Project# 1008492

10DRB-70313 VACATION OF PUBLIC EASEMENT
10DRB-70314 VACATION OF PUBLIC RIGHT-OF-WAY

**CITY OF ALBUQUERQUE
PLANNING DEPARTMENT
September 15, 2010
DRB Comments**

RE: Lot 26, Alvarado Gardens Addition Unit 1 (G-13)

PLAT OF LOTS 26-A AND 26-B ALVARADO GARDENS, UNIT 1

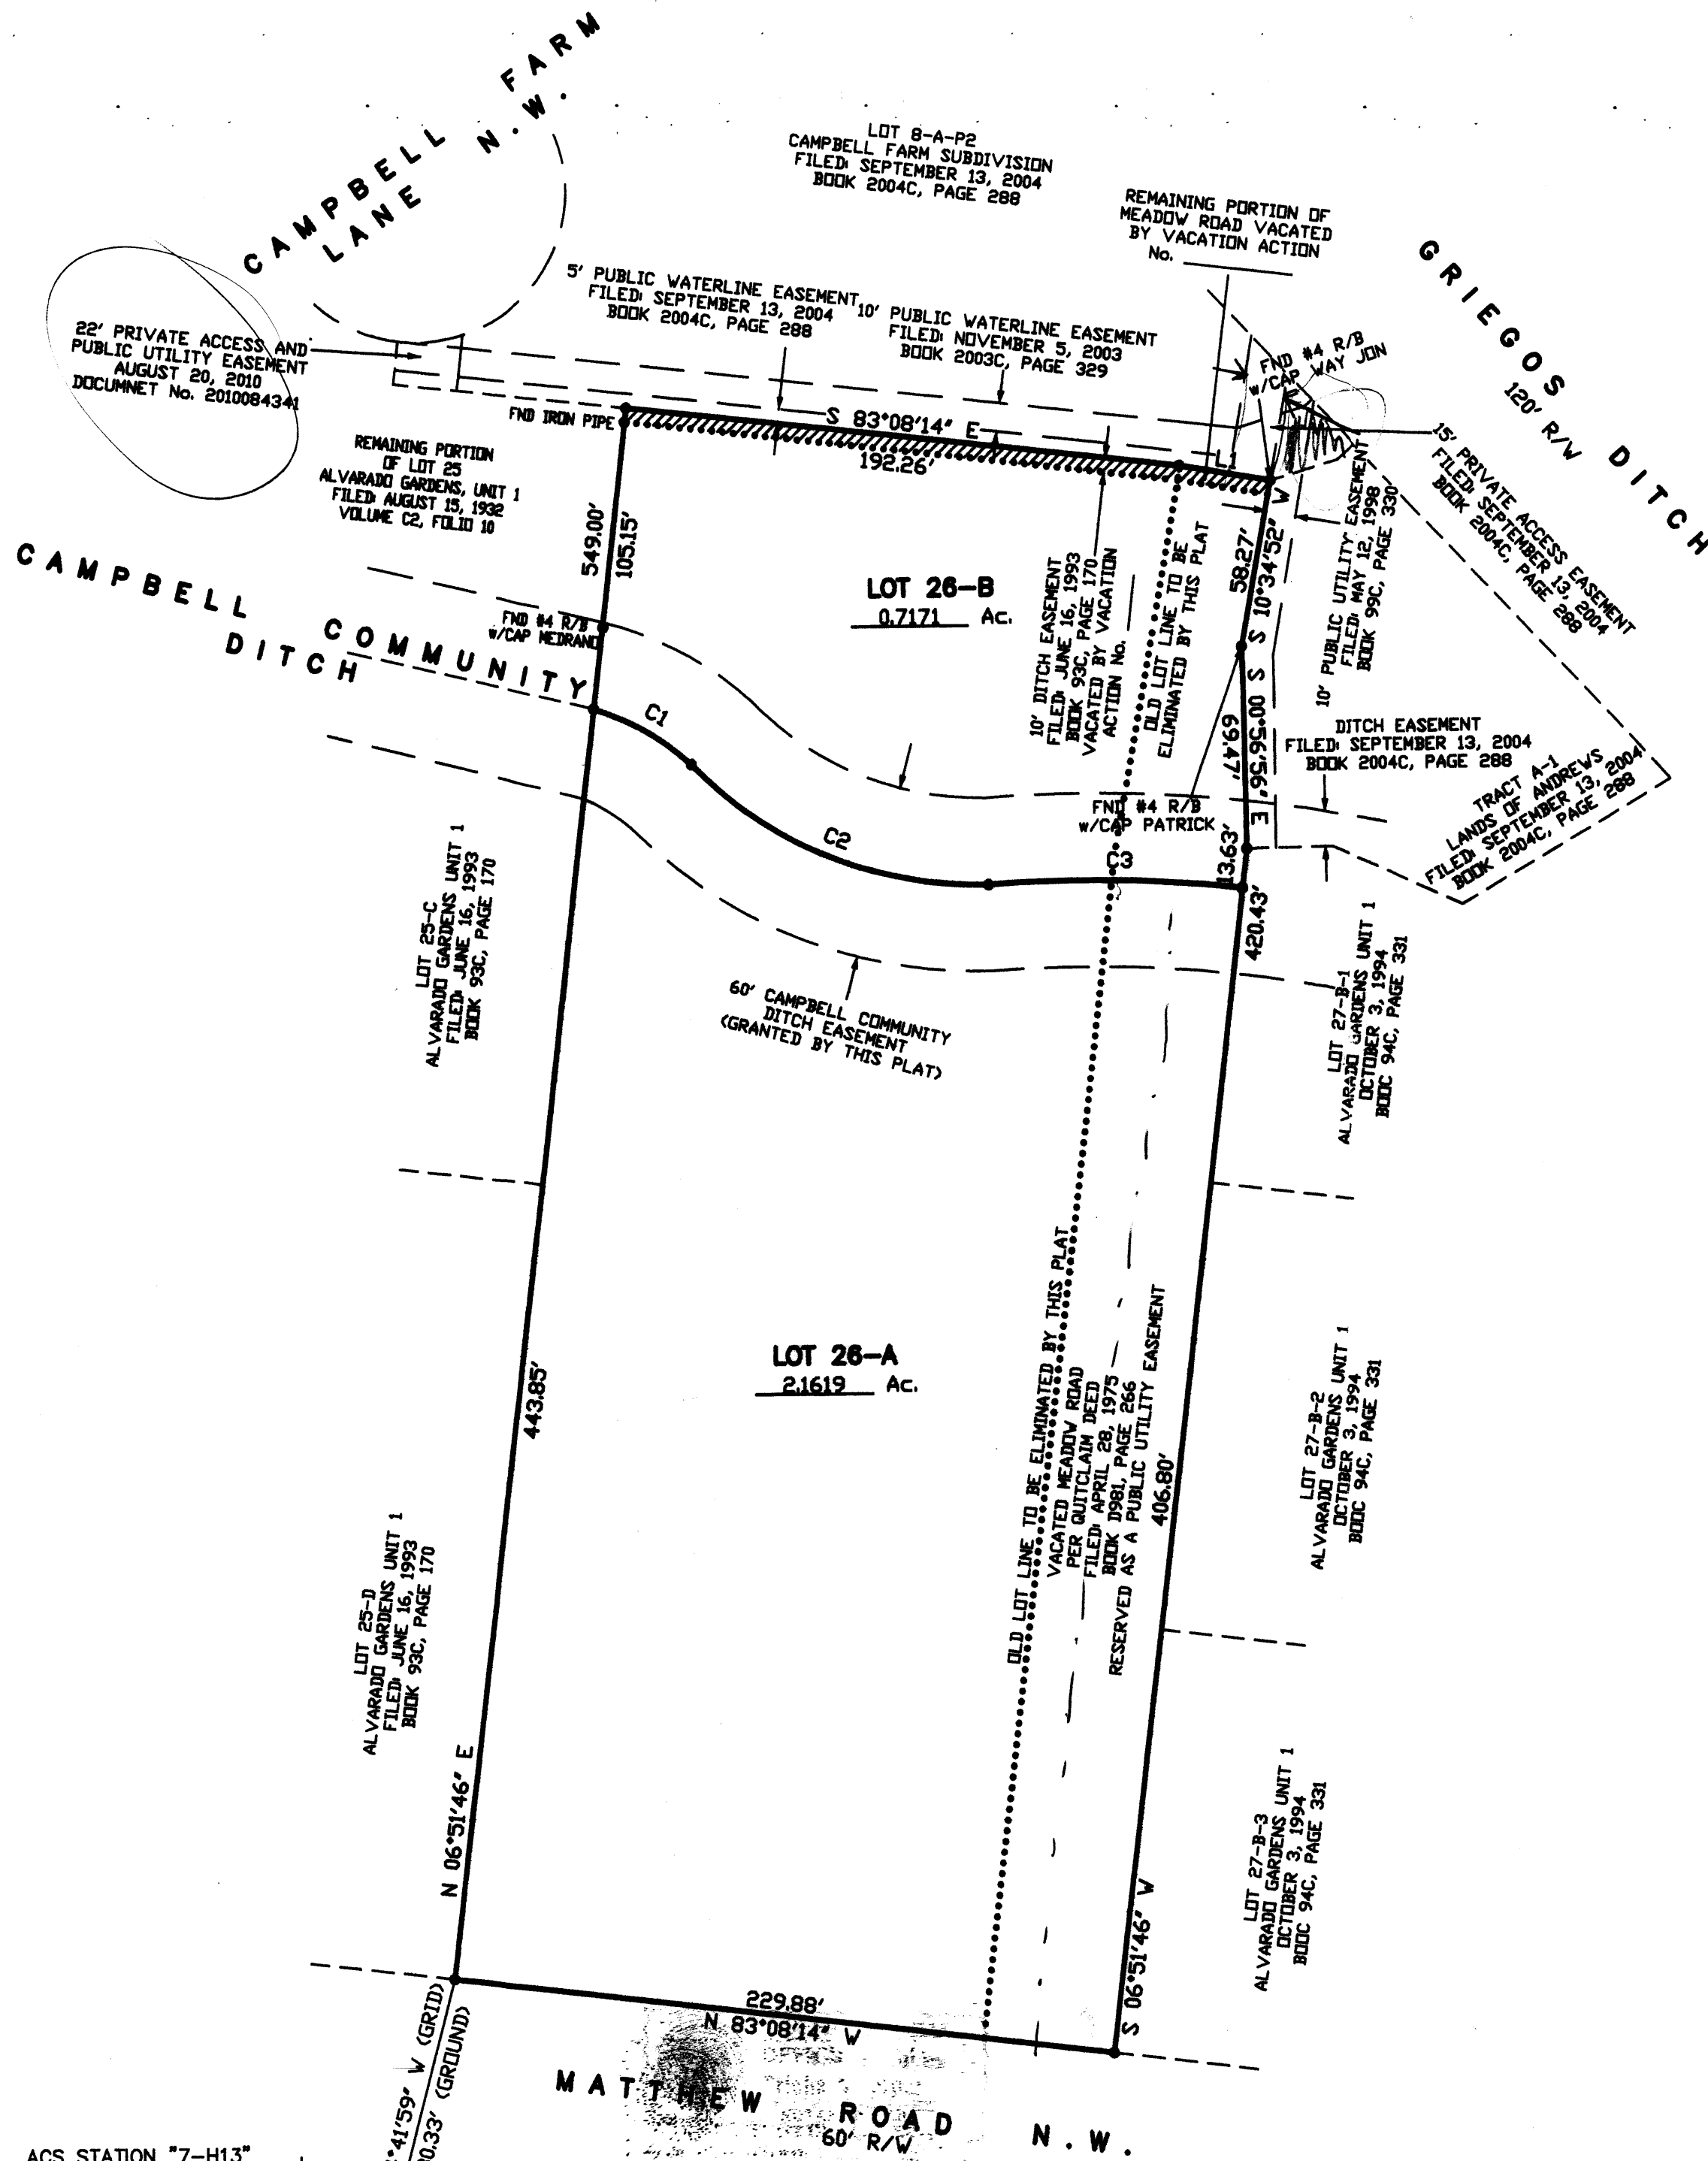
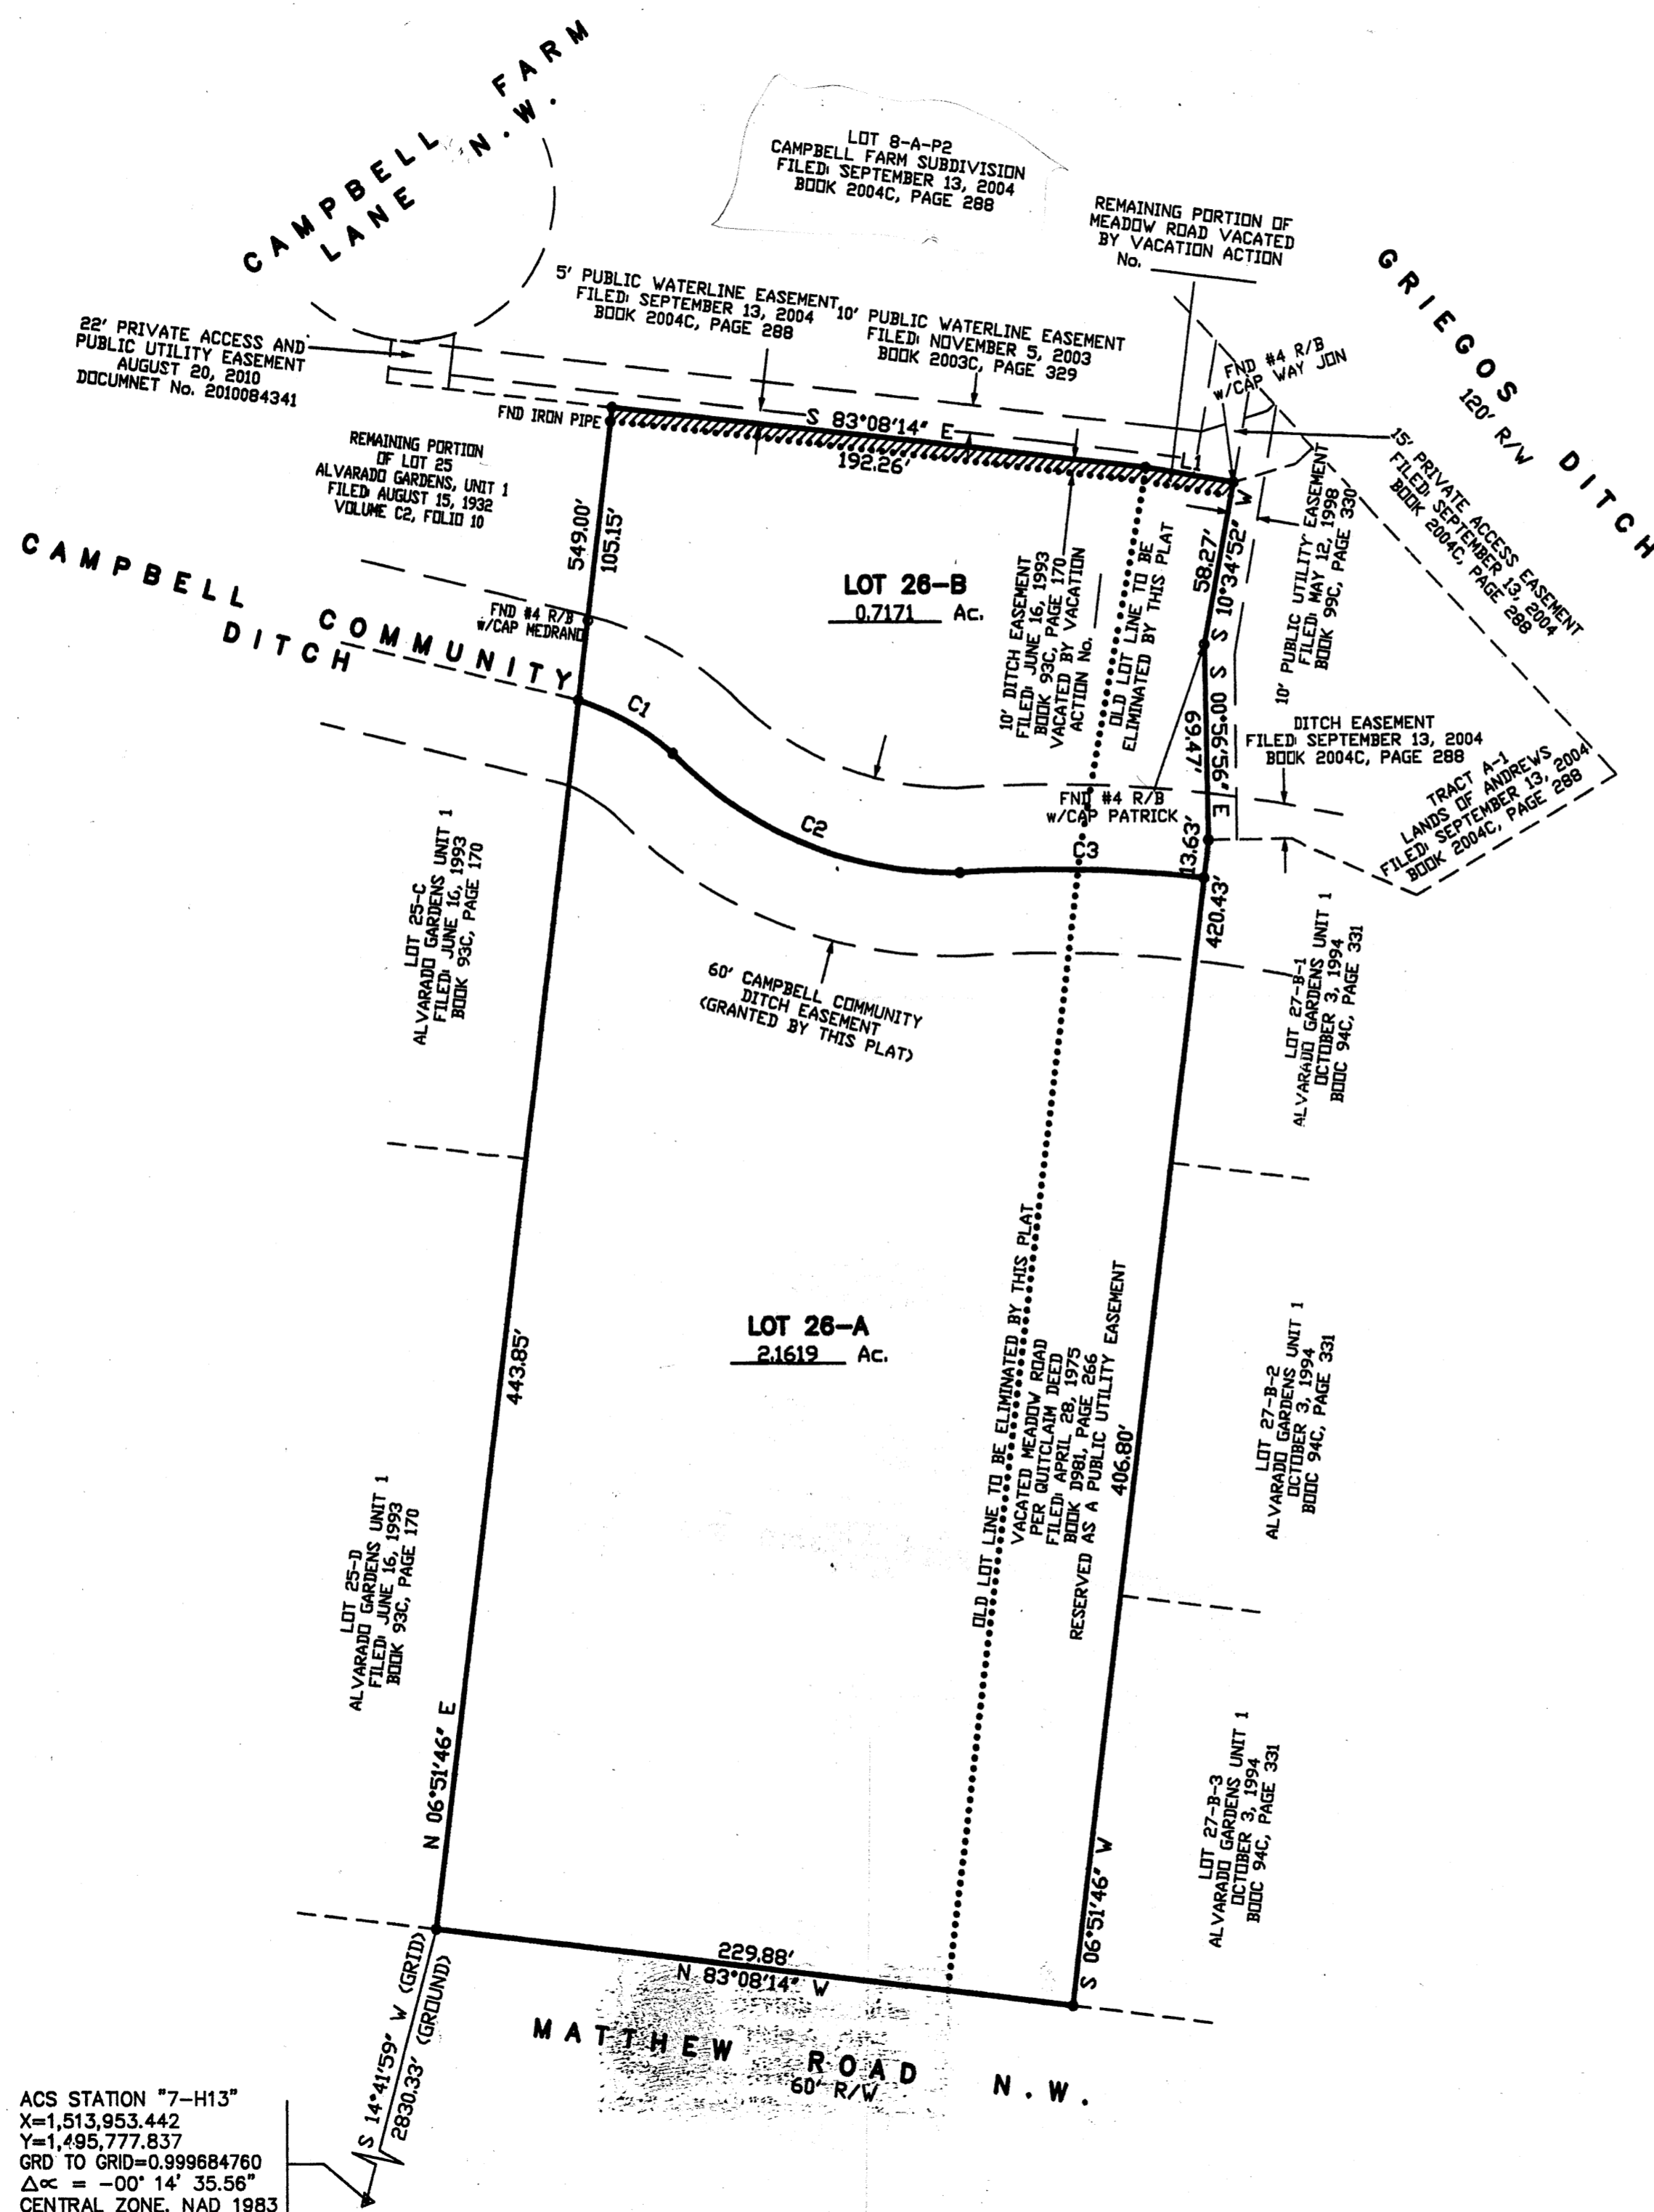
Vacation of 'Ditch Easement' requires a separate application and public hearing by the DRB.

Vacation of Meadow Drive needs to be documented and referenced on the plat.

Access to public right-of-way for proposed Lot 26-B needs to be documented. If this is via the 'Private Access Easement' referenced on the plat, please provide a copy of the recorded easement.

Proposed 'Campbell Community Ditch Easement' is not consistent with the physical location of the existing ditch.

The plat title needs to be corrected, and the adjoining street needs to be corrected (Chadwick Road is on Zone Atlas page E-12 not G-13).
